Our Ref: M/122/17/HH
Your Ref:

Town & Country Planning Act 1990 (as amended)
Town & country Planning (Development Management Procedure) (England) Order 2015
Application for Planning Permission for Works or Extension to a Dwelling

Development Two storey side/front extension & first floor dormer to side elevation.
Location 18 Tudor Close Middleton on Sea

PROPOSED ELEVATIONS

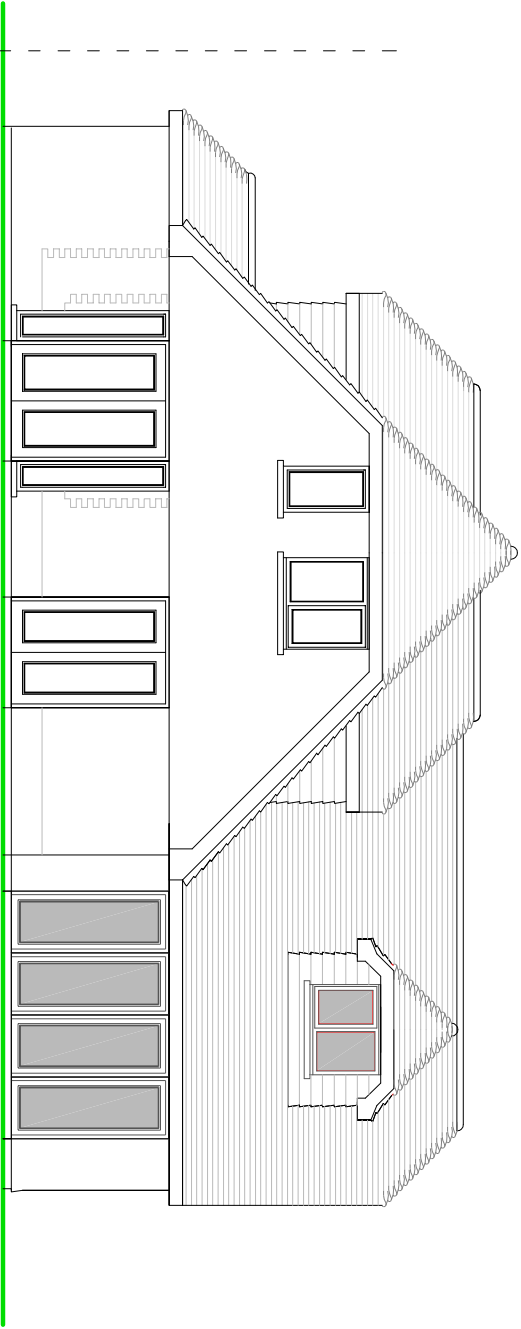
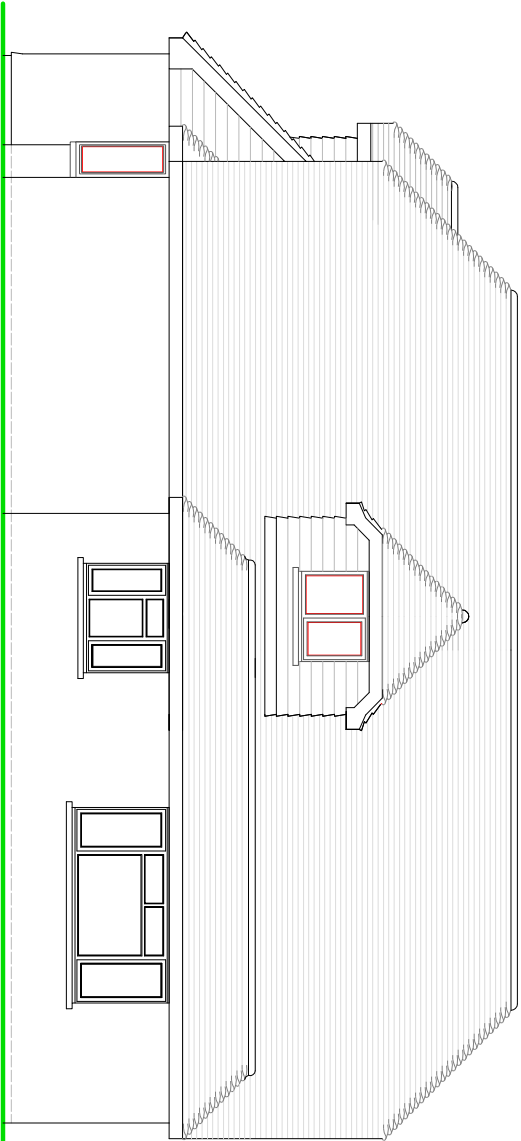
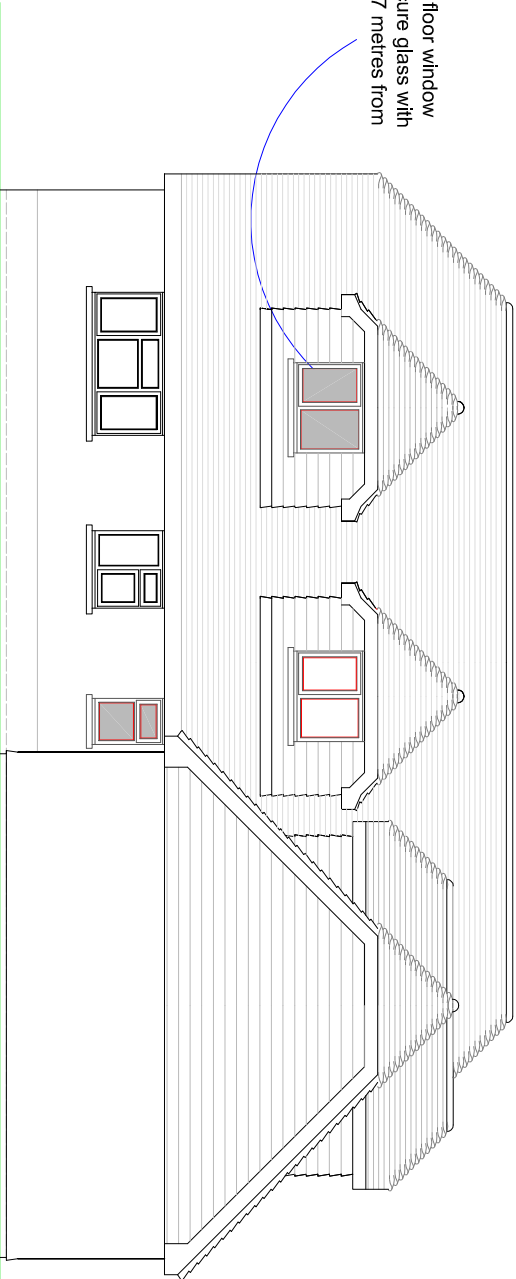
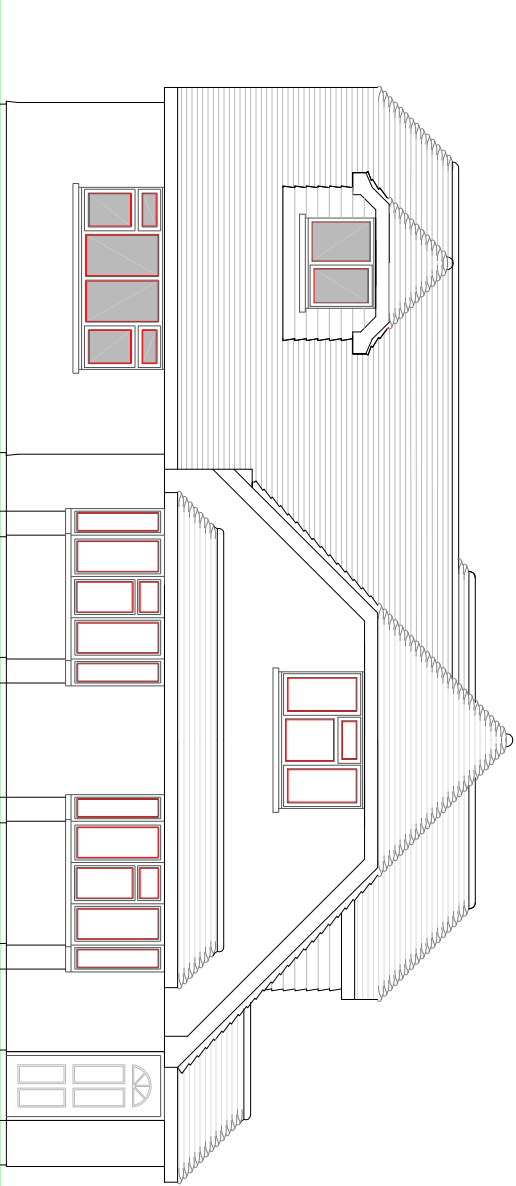
The proposed ground floor plan and side elevation do not accord. Please amend accordingly.
